CITY OF ALBUQUERQUE

**RE: BEK Distribution Facility – 601 Gallatin Pl. NW
G&D Plan and Drainage Report Engineers Stamp Date: 6/25/2019,
Hydrology File: FJ10D002G1**

Based on the information provided in your submittal received on 6/25/2019 the Conceptual Grading and Drainage Plan and report cannot be approved.

GRADING AND  
DRAINAGE PLAN

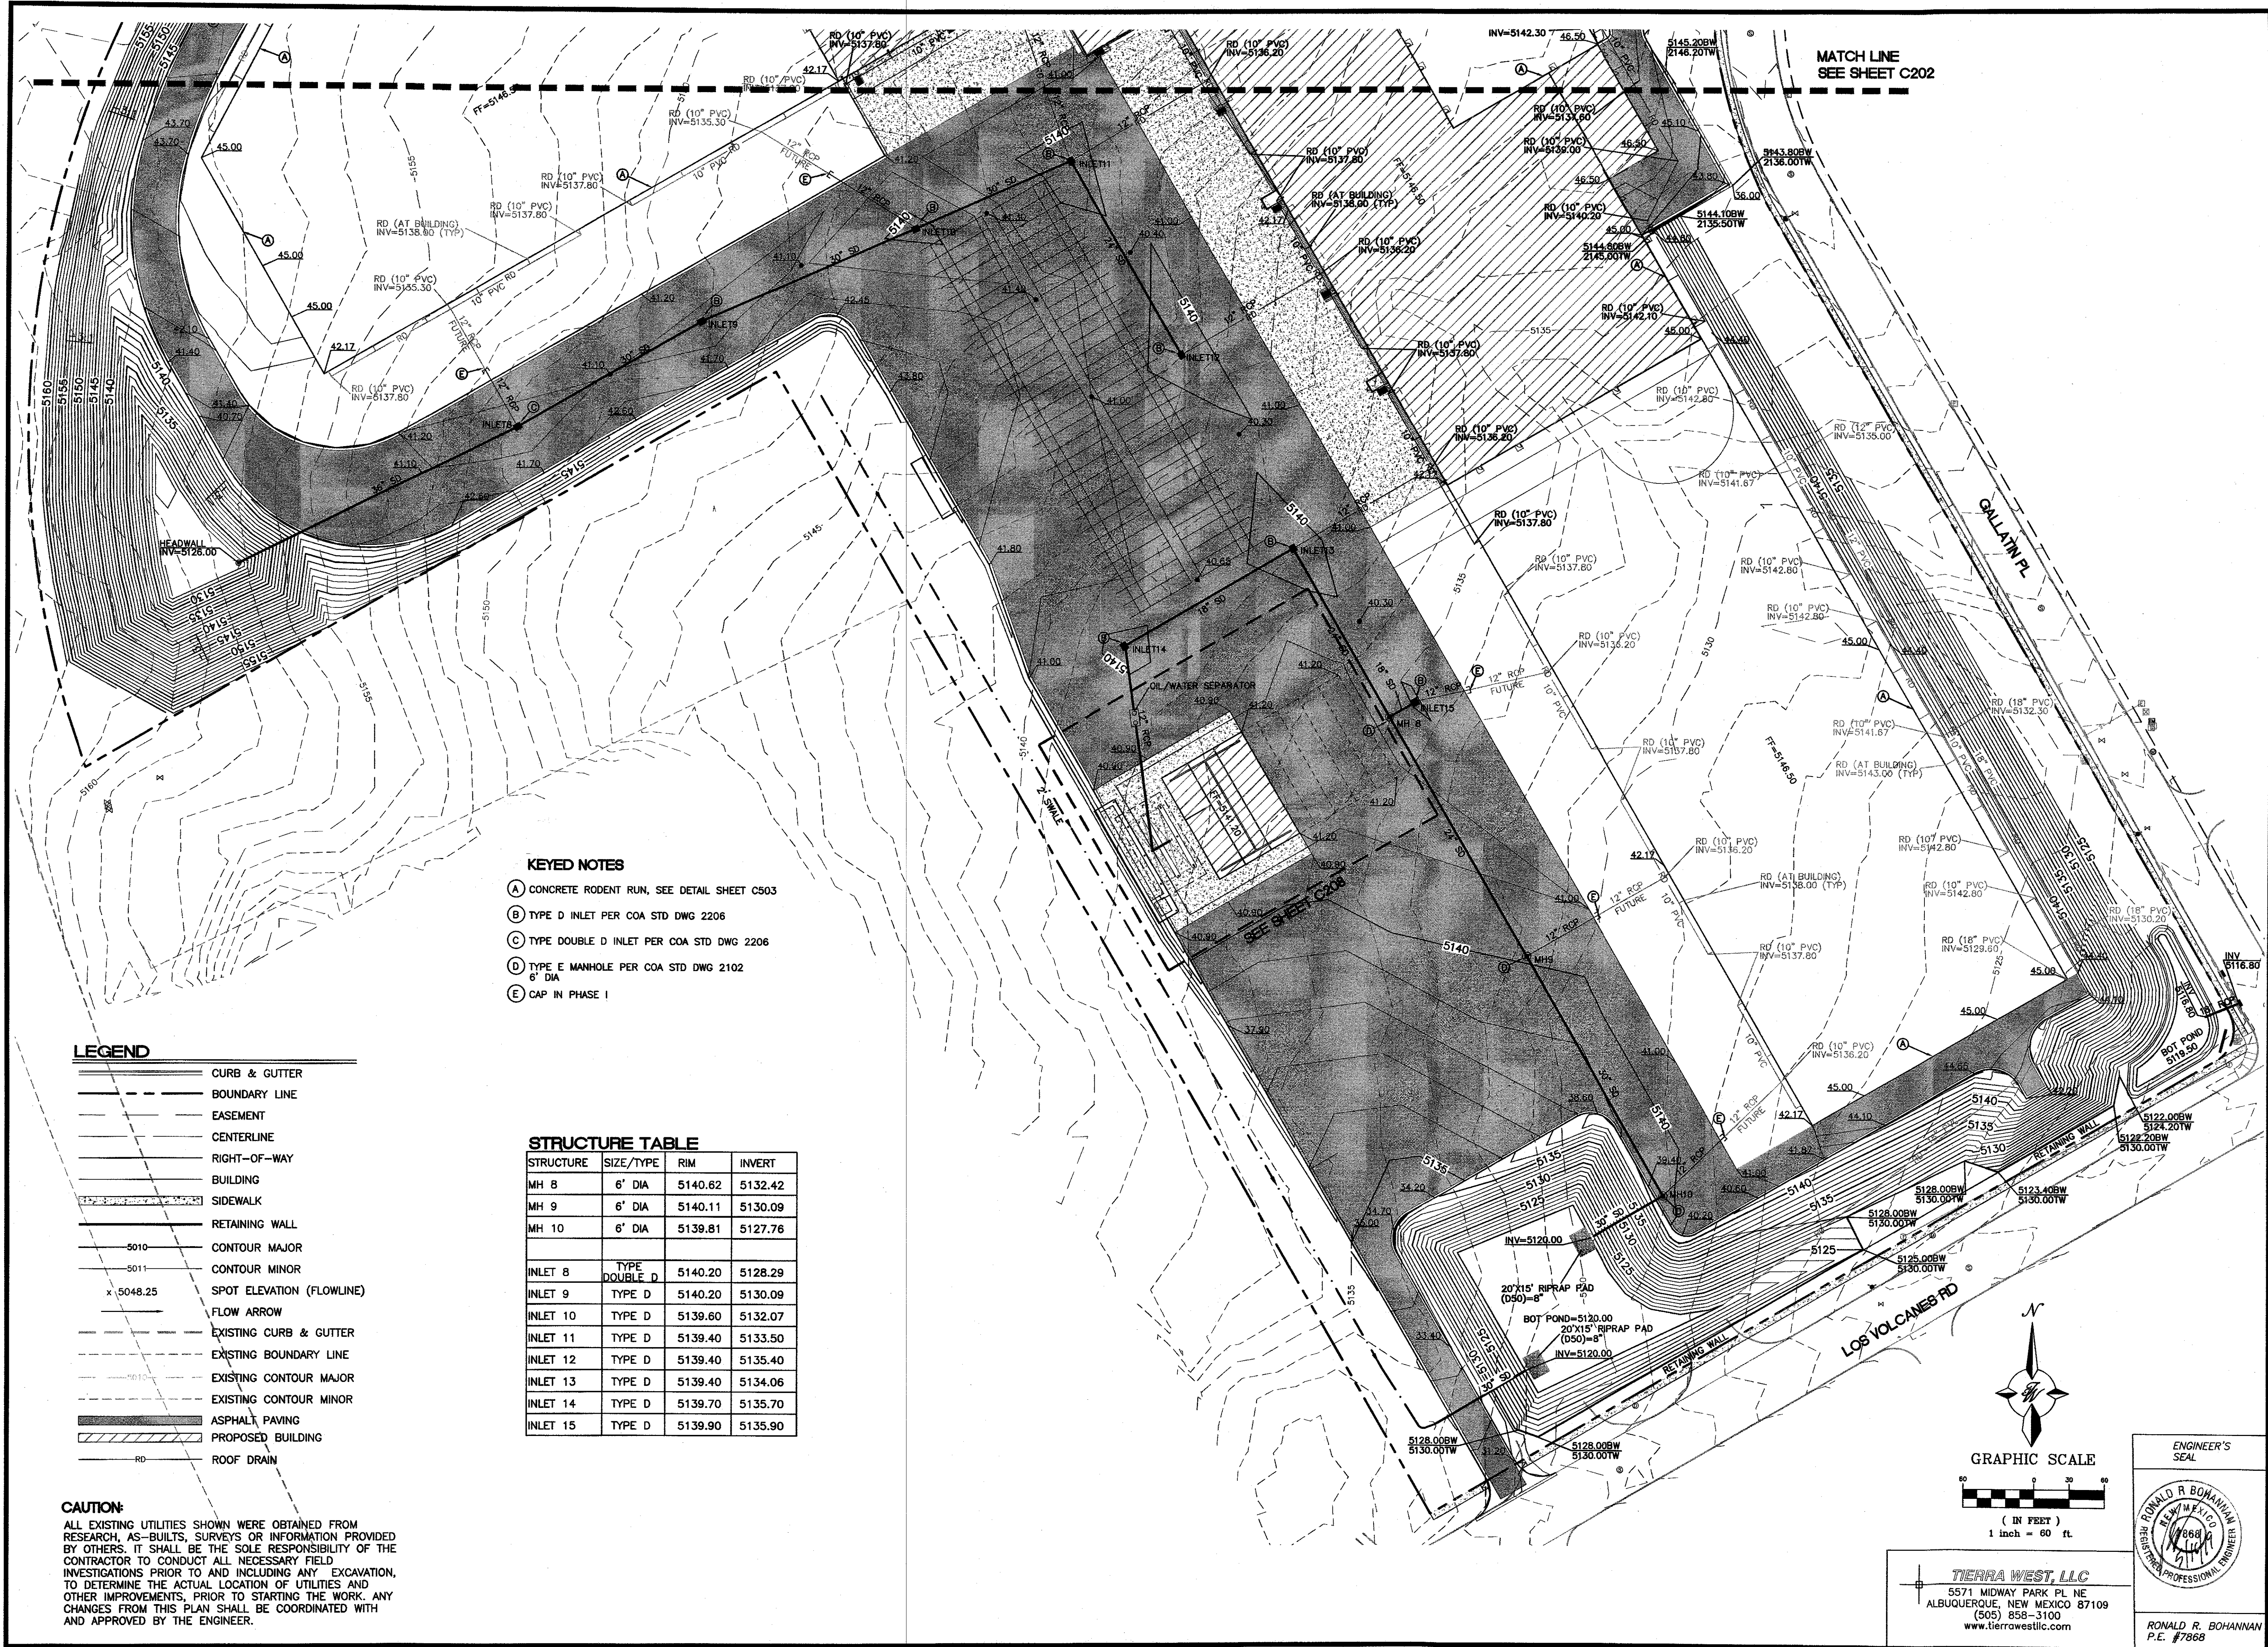
2. Please revise the Pond volume calculations in the report to show that Basins 31 and 32 drain to pond 4 and revise the Direct Discharge calculation.
3. Also please add a calculation of the required SWQV and a statement of how that volume is being provided as note 3 on Sheet C201.

- b. Better survey information must be added to the G&D Plan including detailed survey of the dam, the headwall and pipe outfall, and the emergency overflow spillway.

- c. The existing Dam may encroach on this site. A minimum 6' wide top of dam must be maintained where the proposed construction seems to be cutting into it. Please add a typical section through the dam and property line at the culvert under the south driveway.

6. Remove the word Conceptual from the sheet Title and the label NOT FOR CONSTRUCTION. Also identify how the future building pads will be graded to drain especially where future roof drains are planned to direct that drainage away from the adjacent public streets and into the ponds.

7. Key note 25 on the Site Plan calls for a 6" temporary header curb that is not shown on the G&D Plan. Please revise one or the other so they agree, and provide a copy of the revised Site Plan when resubmitting to hydrology. If the temporary curb is to remain please add details of the curb on the G&D Plan with spot elevation that show how the parking lot will drain thru the curb.

8. How will drainage get out of the sump in the C&G on the east side of the Staging area?
9. Surface drainage in the future staging area and the future parking lot next to the pond appears to enter the pond in two places but only one has a rundown. Lined conveyance systems should be added to the plan to convey drainage from the paving proposed with this building permit through the future paving area and into the pond. Please revise the G&D Plan adding lined swales and typical sections through the future north parking area and into the north pond.

10. Please label the contours in the north east corner of the parking lot and verify that the spot elevations agree with the contours. If they are not 5141 and 5142 then please revise the grading to decisively contain the parking lot drainage and convey it into the north pond.

11. The contours indicate erratic slopes varying from 1% to 10% with abrupt grade changes in the northwesterly 250' of the staging/parking lot. Please revise the grading.

12. Additional right of way may be needed for the hammerhead turnaround at the west end of Fortuna Rd. Please coordinate with transportation and if additional ROW is required then show the right of way dedication on the G&D plan.

13. Please show the PNM easement adjacent to and on this tract in the west corner. Either revise the plan to eliminate the grading within the easement or provide written permission from PNM for grading inside of their easement.

14. The finished contours are missing between the retaining wall and the street in Los Volcanes Road. Please show proposed contours all of the way to the existing street to indicate the proposed grade of the sidewalk in the public right of way and the landscape area on the private side of the sidewalk. Also please add a few typical sections showing the grade on both sides of the retaining wall, the new sidewalk, the ROW line, the fence, and the slope.

16. Please add the Book and Page (B 2019C P 0040) of the plat to note 1 on sheet C201.
17. The south pond must have a non-erosive spillway. Please add a build note and a detail on the G&D Plan. Please check the weir coefficient, 1.6 is for metric units, 2.7 is SI for broad crest, and 3.3 SI for sharp crest.

21. Please revise the grading of the south pond so a floodwall is not expected to hold back drainage.

STORM SEWER  
PLAN AND PROFILE

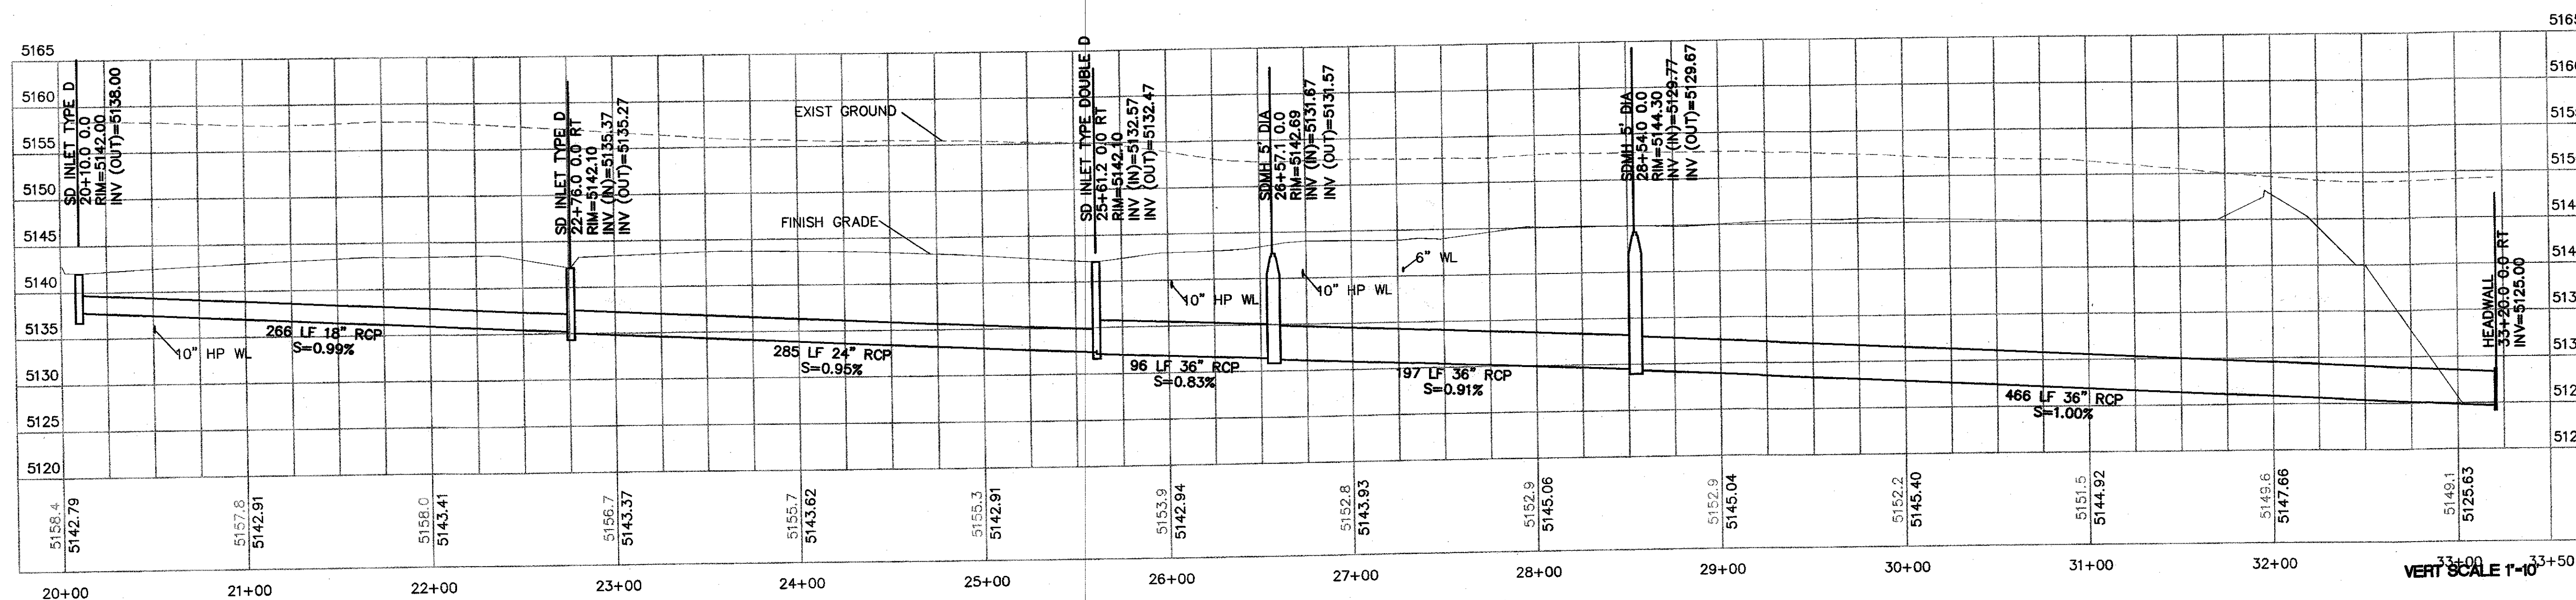
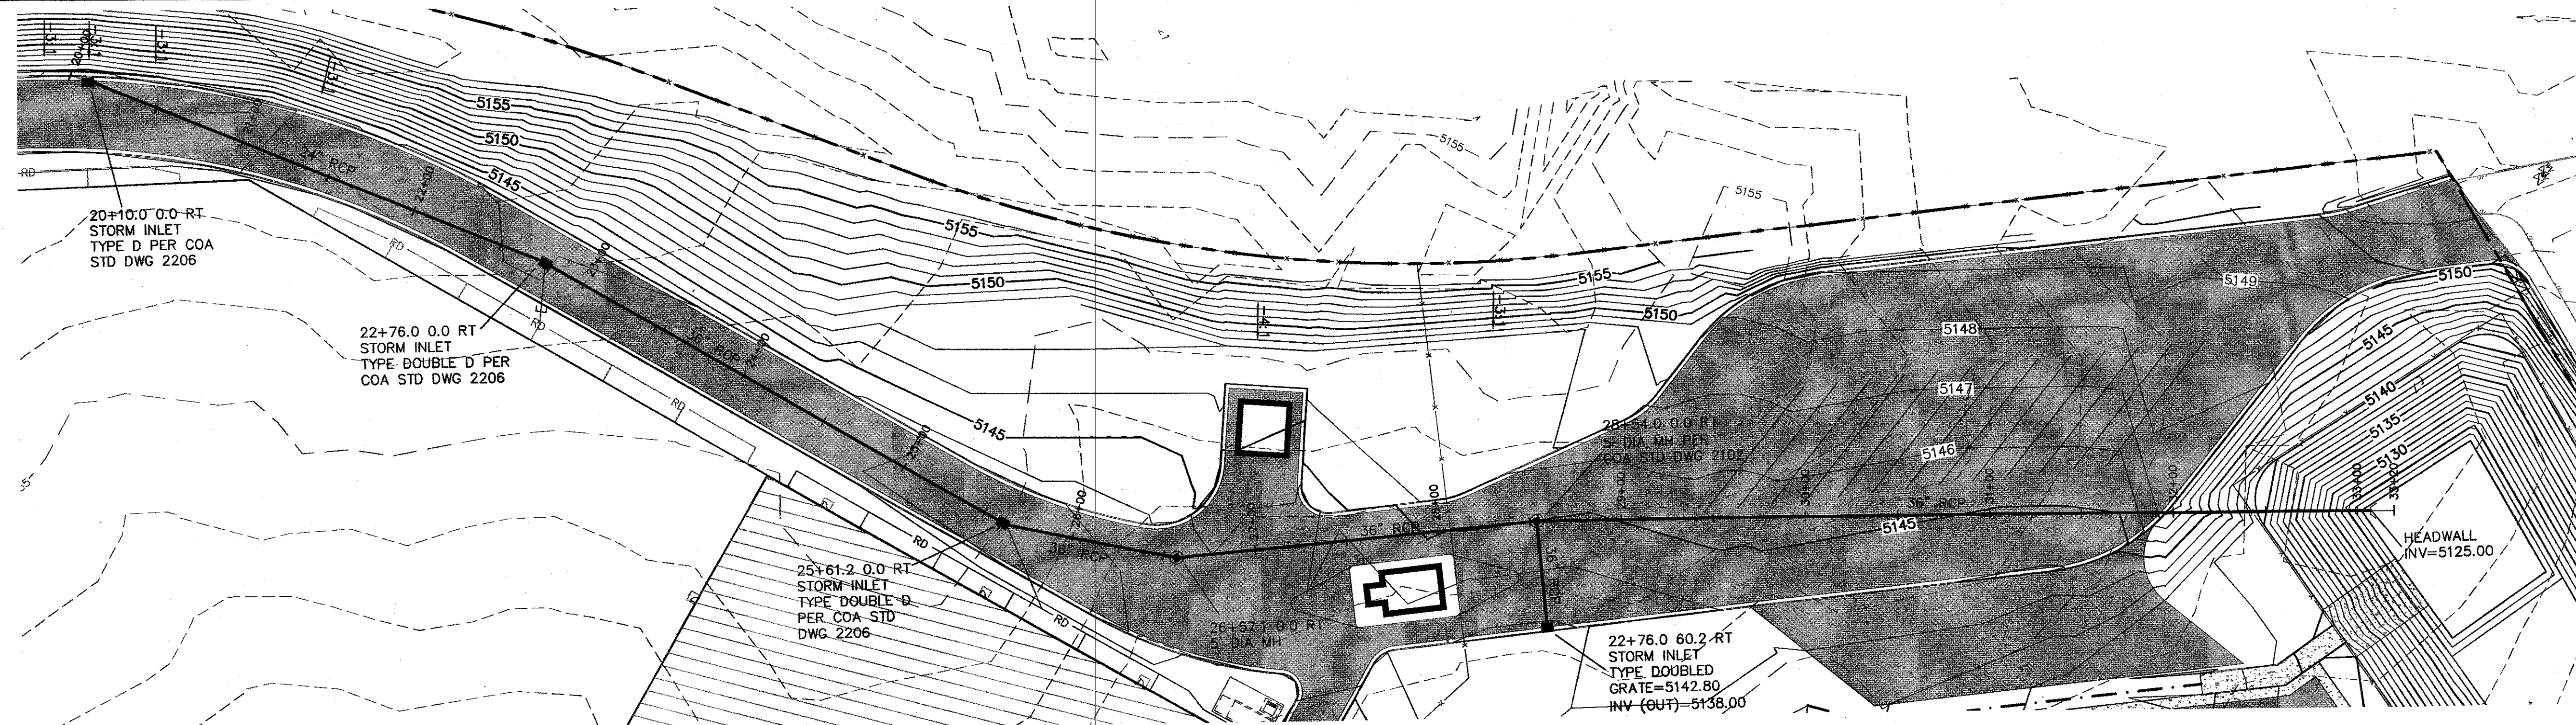
15. HGL calculations are required for the storm drain in the north east corner of the site where failure of the storm drain could result in excessive stormwater runoff to public streets. Also please add a profile and HGL calculations for the storm drain on the south and east side of the building.
